Design Note

Project: Field House

File ref: NOTE-1013359-5A-LR-20210811-Facade requirements note-Rev00

Façade sound insulation requirements.

PROPOSED ELEVATIONS

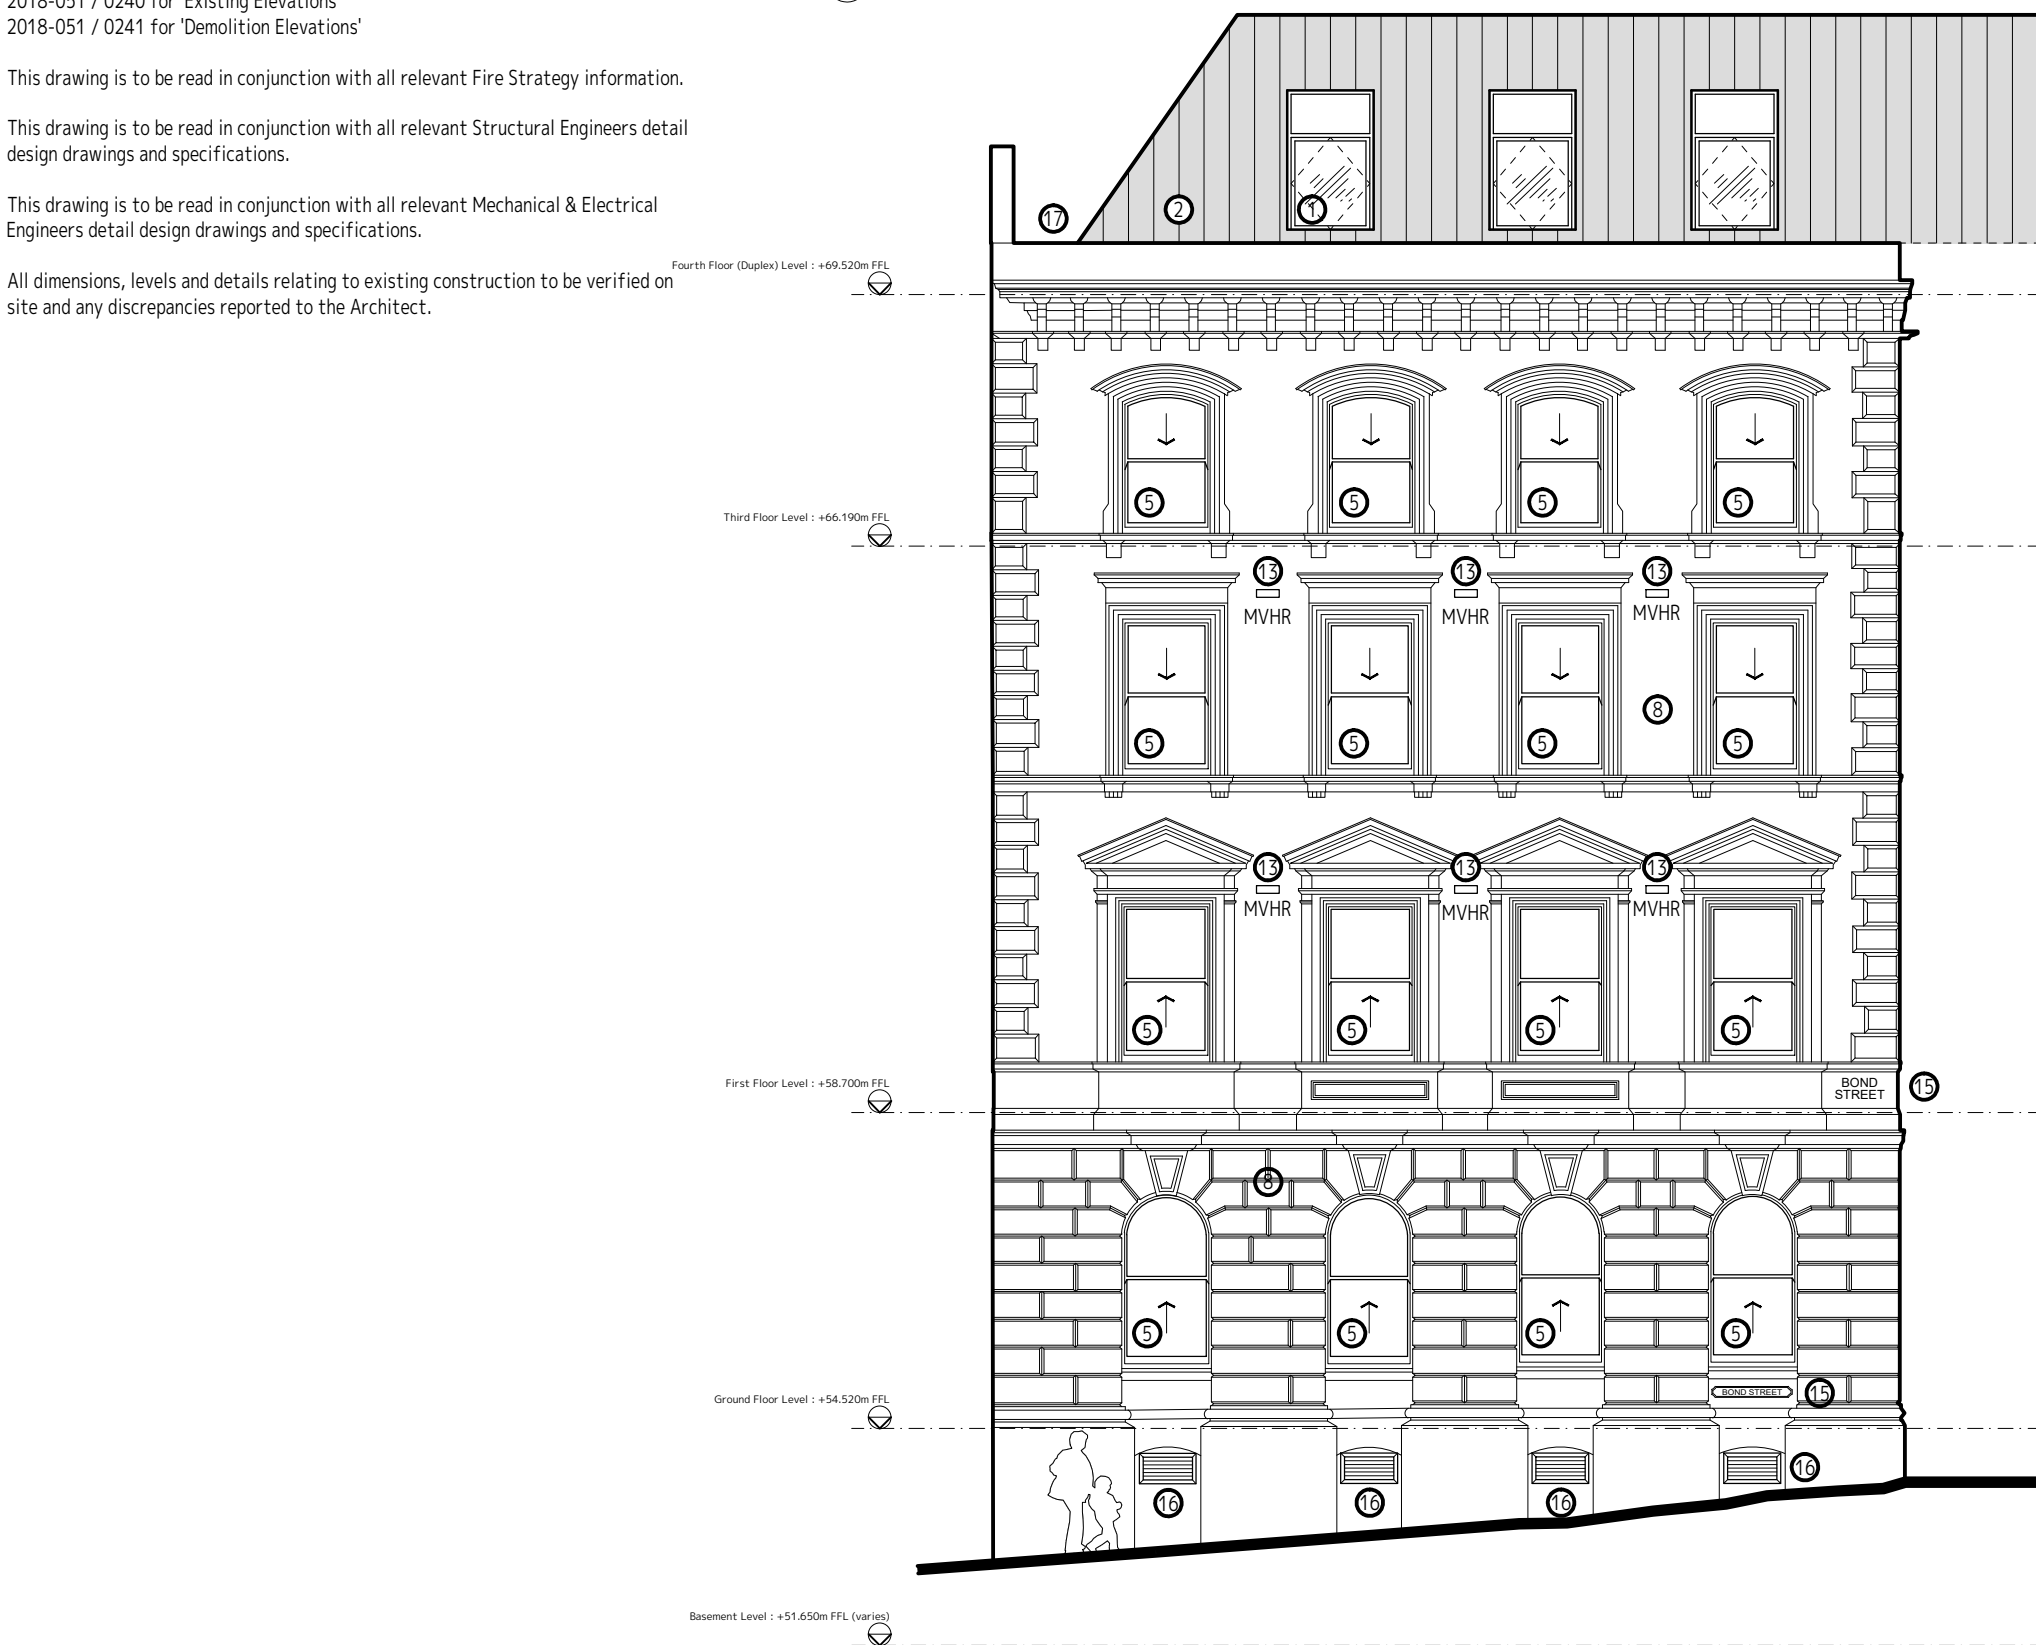
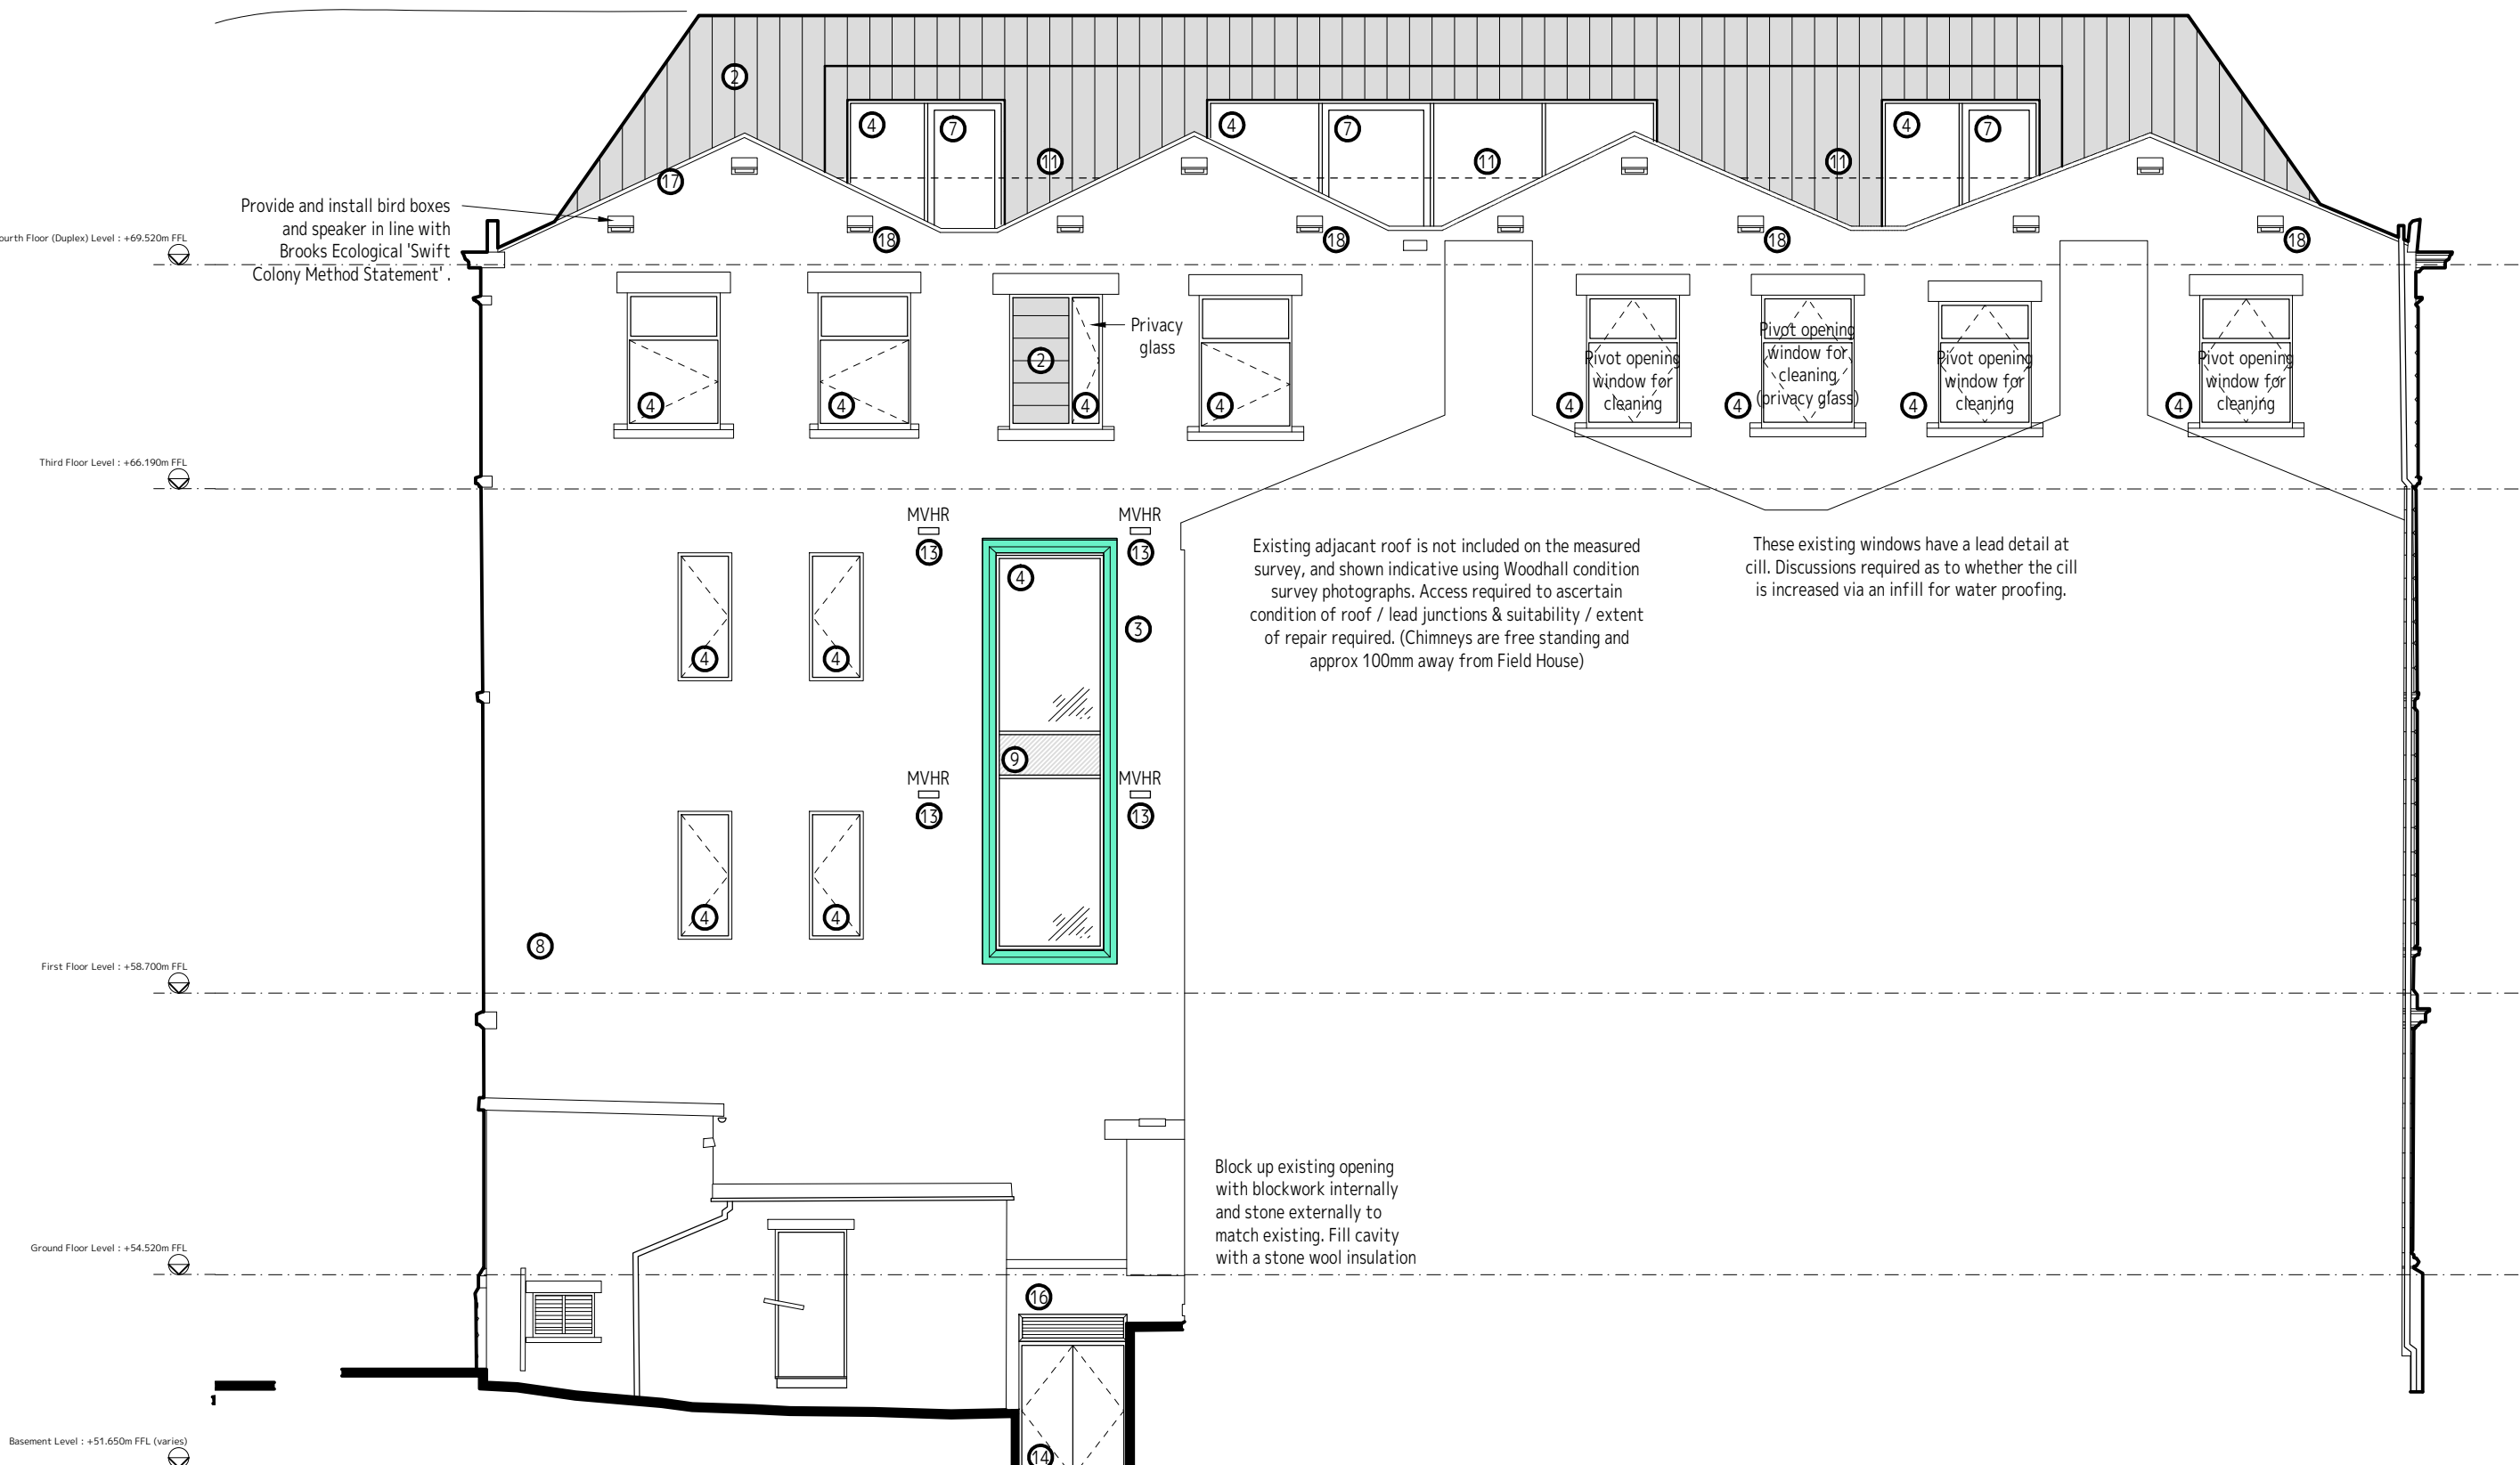
Confirmation is also requested on whether any heritage constraints imposed upon the scheme require the installation of sash windows, as the performance through these elements can be limited

It is understood that the current proposals comprise routing support and extract ducting via the external façade and not via louvres above the windows due to heritage constraints. Consideration to the acoustic integrity of this detail will need to be made as the design develops and more information becomes available such that the acoustic integrity of the façade is not compromised via this route.
